REQUEST

Current Zoning: B-2 PED (general business, pedestrian overlay)
Proposed Zoning: B-2 PED(O) (general business, pedestrian overlay-optional)

Approximately 0.18 acres located on the south side of Central Avenue, east of Pecan Avenue and west of Thomas Avenue.

The petition proposes to allow the reuse of an existing building with commercial and restaurant uses without requiring additional parking, on a lot located in the Plaza Midwood business community.

**RZ-1**

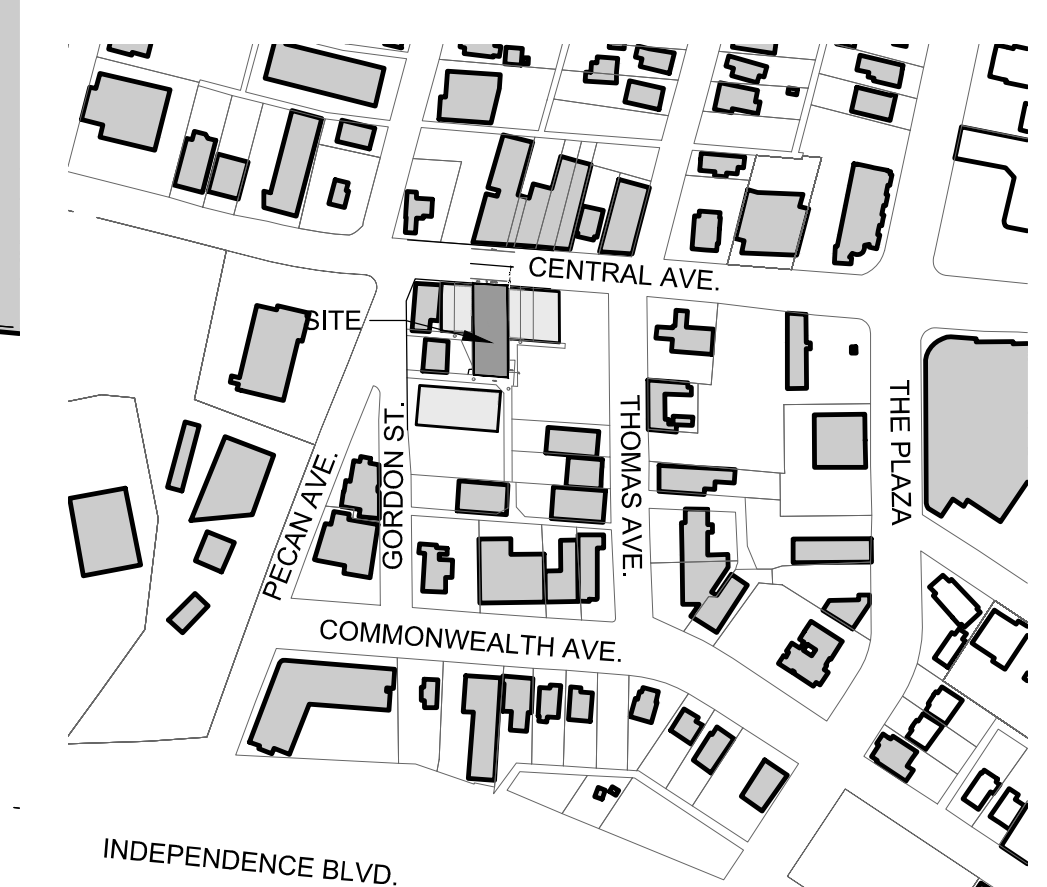
- ~~5. Correct misspellings on site plan under *Maximum Gross Square Feet of Development*. Addressed.~~

**RZ-2**

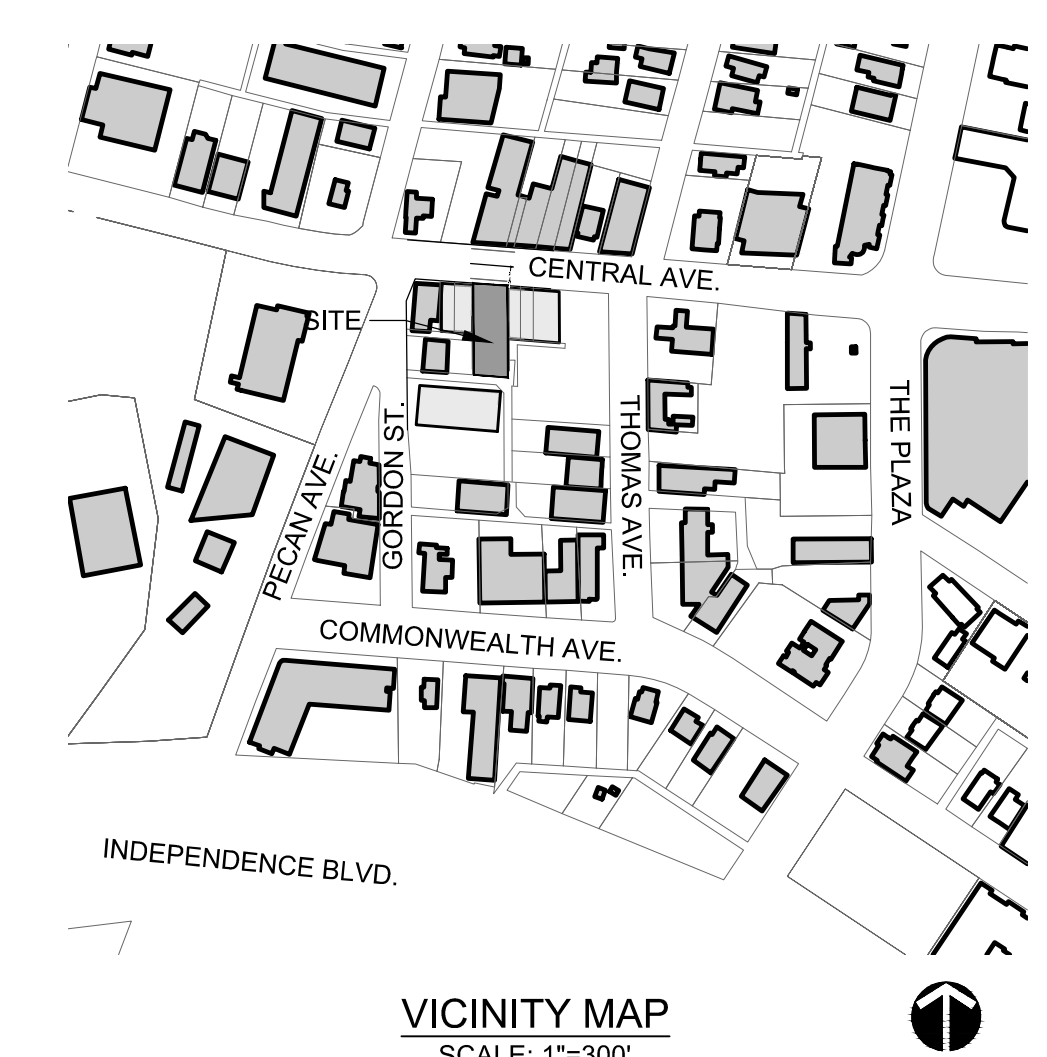
- ~~1. Remove Optional Provision 2.f. from the site plan. Addressed.~~
- ~~2. Specify type of lighting proposed for alleyway as indicated in Note 7.a. Addressed.~~
- ~~3. Clarify type of paving proposed for alleyway. Addressed.~~
- ~~4. Amend Note 3.c. and other applicable language on site plan to provide a clear commitment to preservation of the existing building. Addressed.~~
